Agency Review Comments

Project Name Falcon Highland Sketch Plan Amendment
Applicant Matrix Design Group, Inc.
EA Number EA2116
File Number SKP214
Project Manager Kari Parsons (kariparsons@elpasoco.com)
 (719) 520-6306
Status Active
Created 2/12/2021 9:58:05 AM

Original:

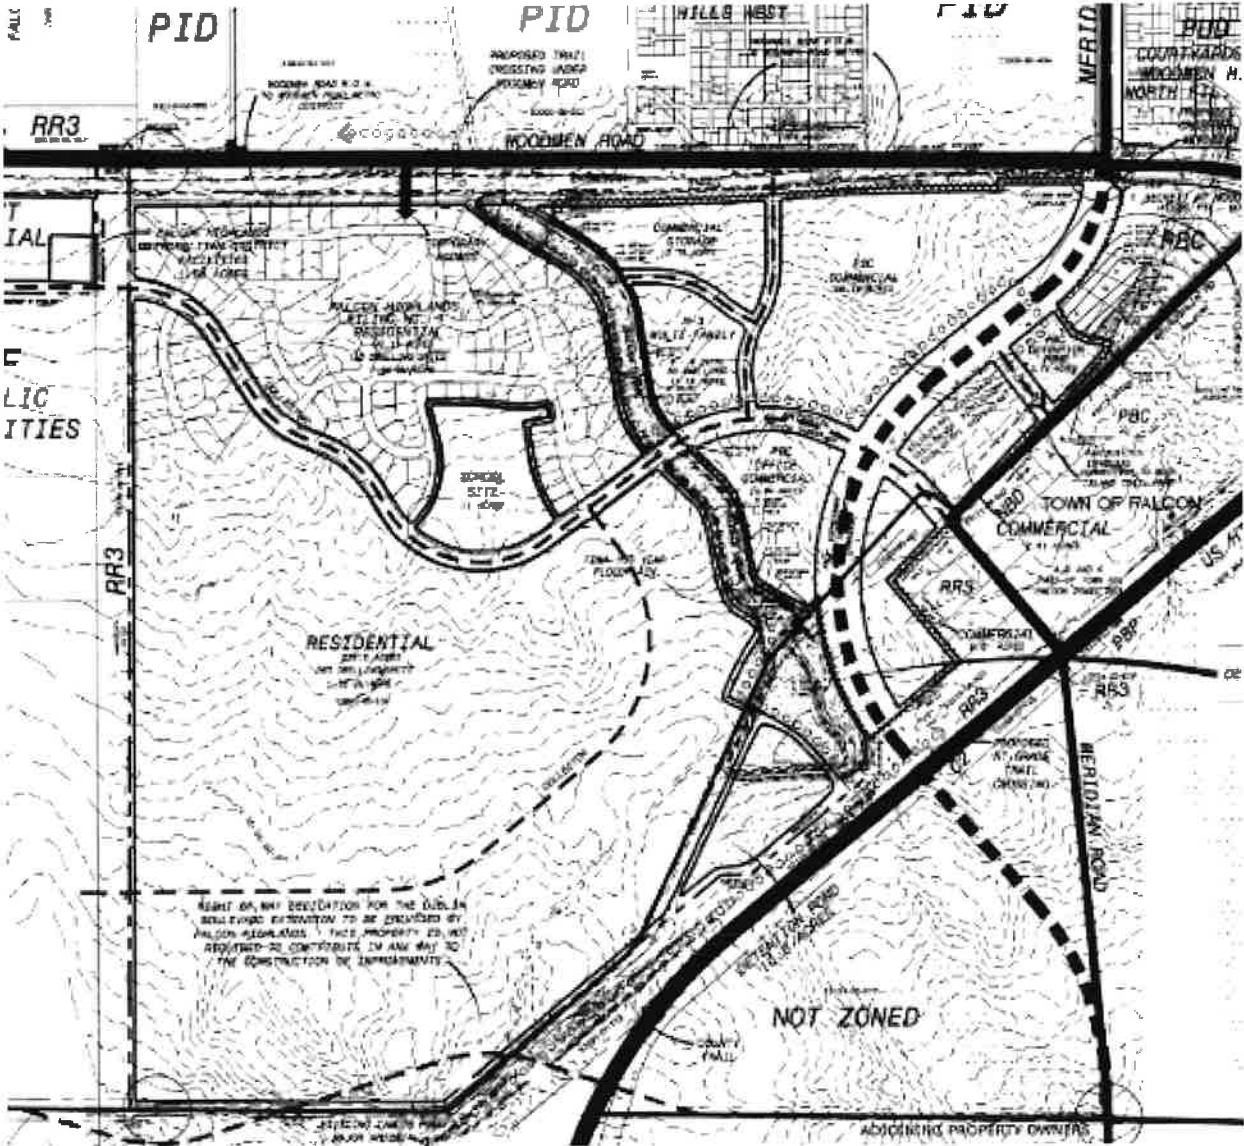
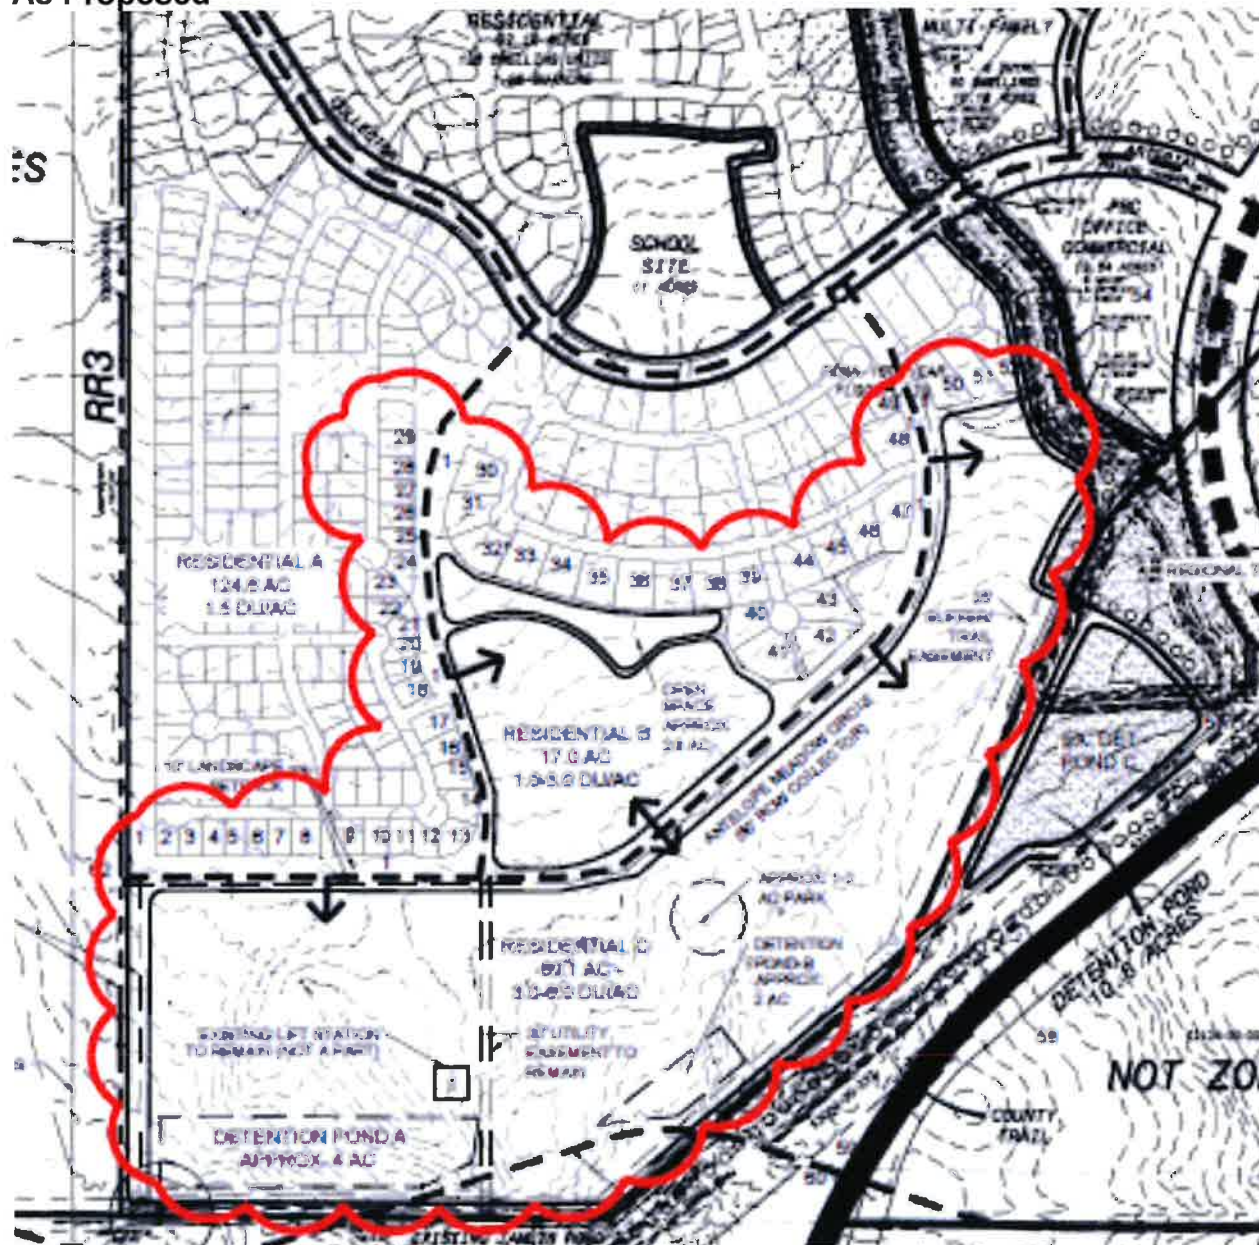
carry over comment- clarify :Is there is a reduction in open space from the current PUD and SK or is it staying the same in this amendment? Or is it decreasing...state justification or rational

there is a 2 acre park and also a pond as open space

RESPONSE: This sections updated to discuss the open space.
